***The Malt House
Weavers Hill
Angmering
West Sussex
BN16 4BE***

Planning Applications A/24/21/PL
A/25/21/A

I refer to the above Planning applications, and wish to register my objections to both.

Project
**Land at Water Lane,
Angmering, West Sussex.**
Drawing Title
Sales Area Layout

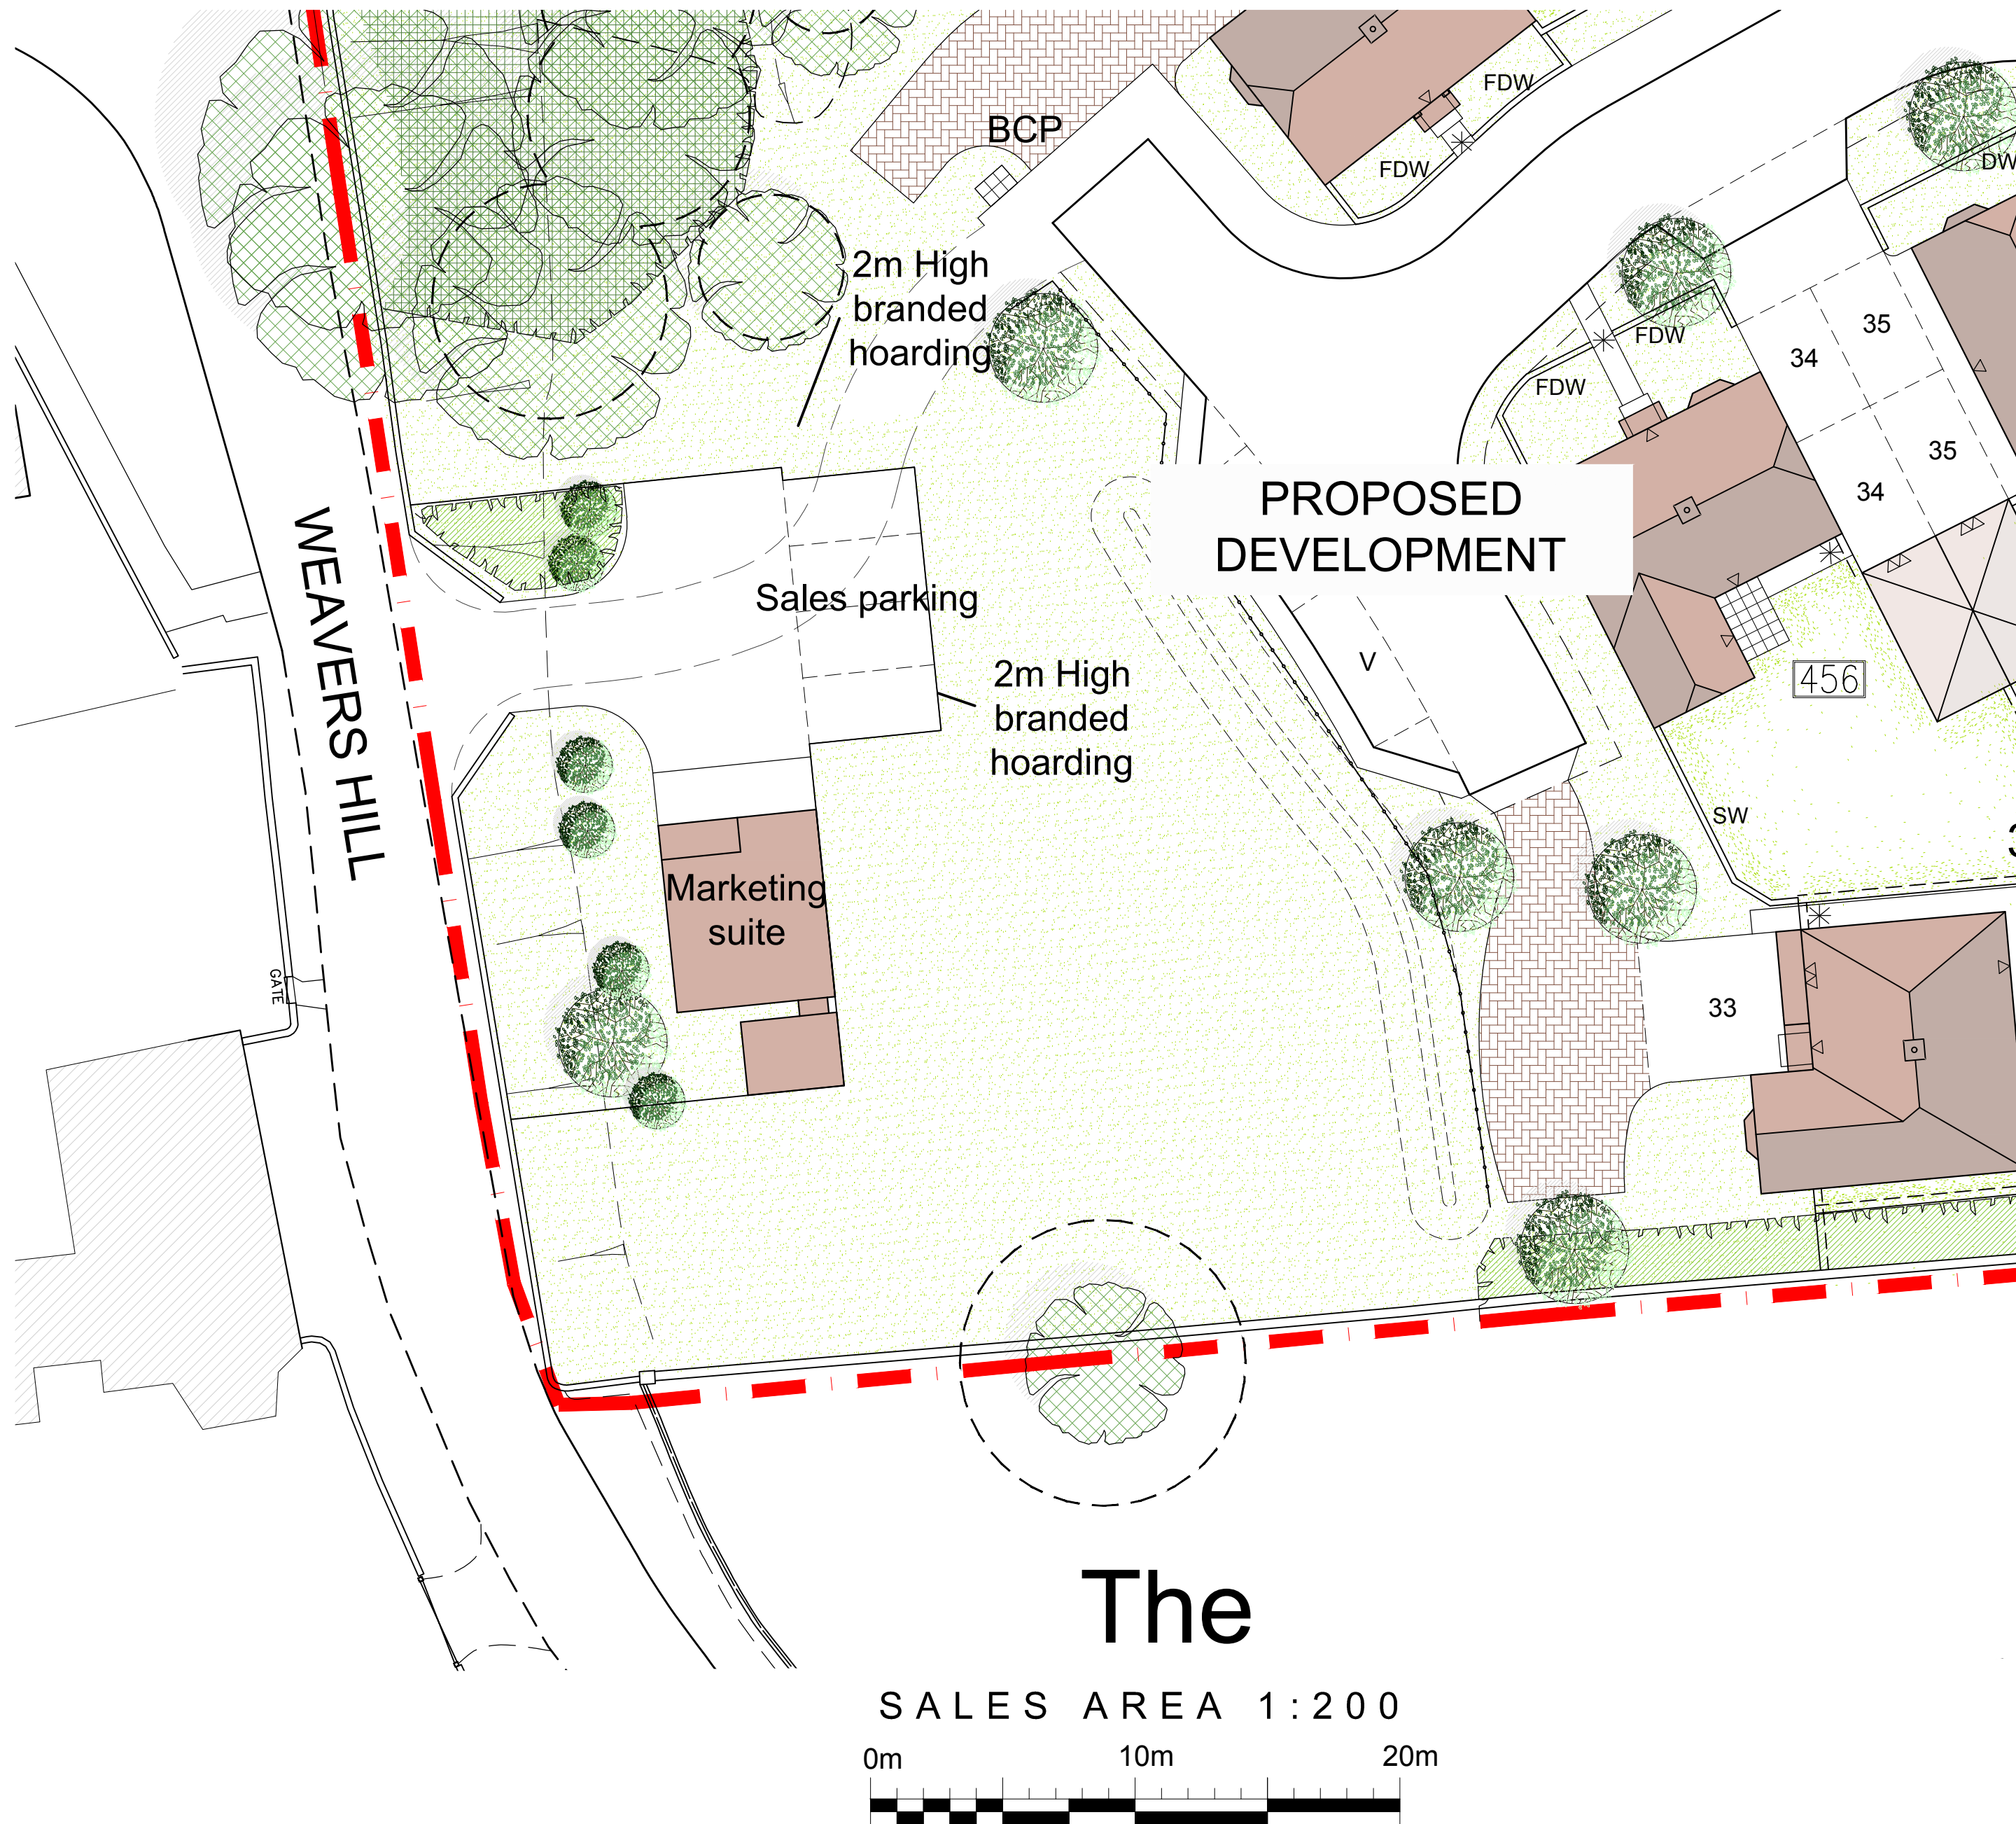
The access to the proposed Sales site requires part of the flint wall to be demolished. The wall is within the Angmering Conservation area, is protected and cannot be demolished. This would also apply to the proposed cycle lane. There is already an exit by the bus stop which would provide access for cycles and pedestrians, the cycleway should be relocated to that point.

The proposed access is just past a blind bend, and without significant visibility splays, it will be impossible to see any vehicle attempting to leave the site, whether travelling up or down Weavers Hill.

Item 2 - Quantity 5
STATIC BANNER FLAG POLE COMPLETE WITH DOUBLE SIDED FLAG

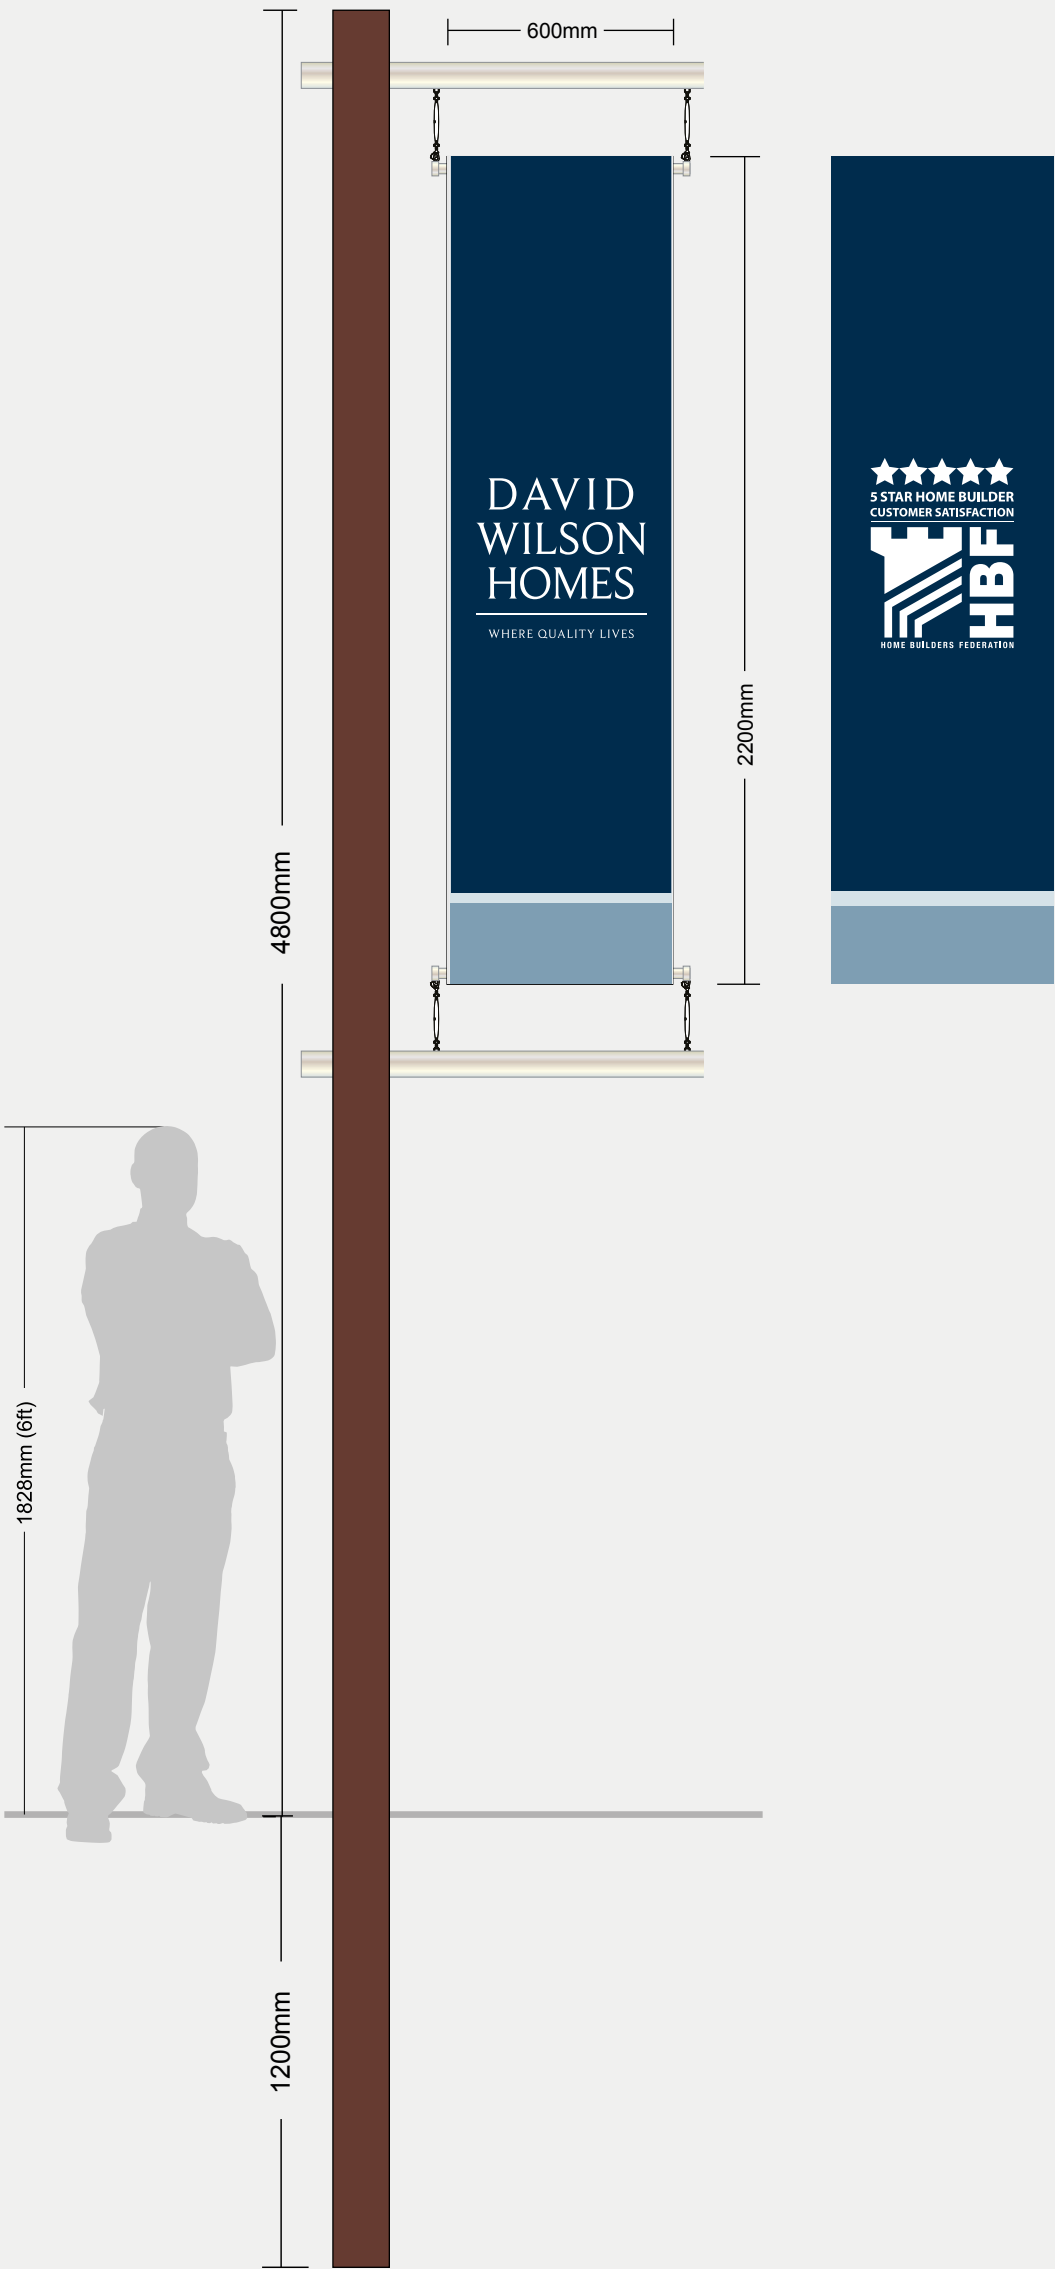
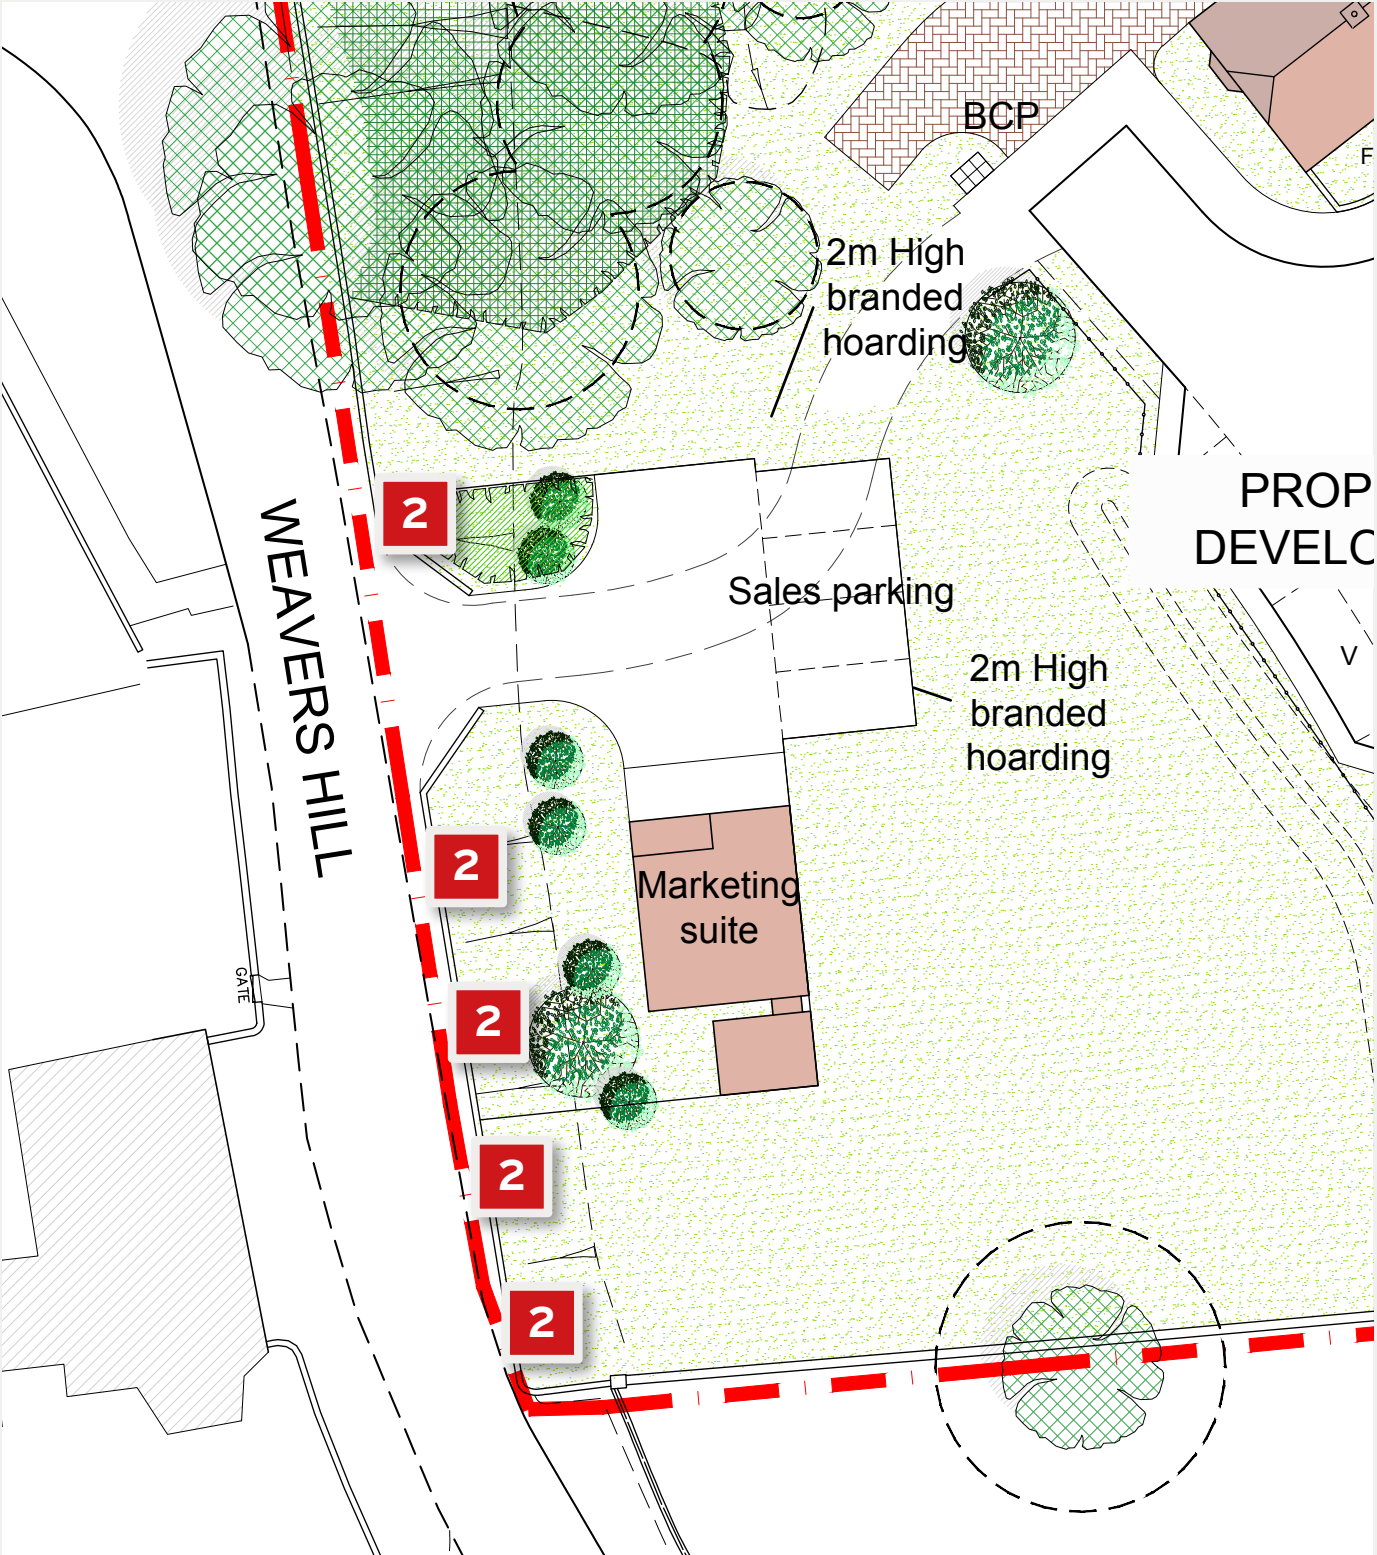
The application also includes the provision of Flag Poles, Banners, and 2m high branded boarding. This will presumably be the usual large photos of the proposed homes for sale. The Barrett Homes Design and Access Statement, quotes "the signage is modest and is not proposed to detract from the visual quality of the surrounding Conservation area". The proposed Sales site described above could never be considered to be sympathetic to the oldest part of the village, and adjacent to a Conservation area. It is totally inappropriate. The request for 5 Flagpoles with Banner Flags should be turned down purely on the grounds of noise.
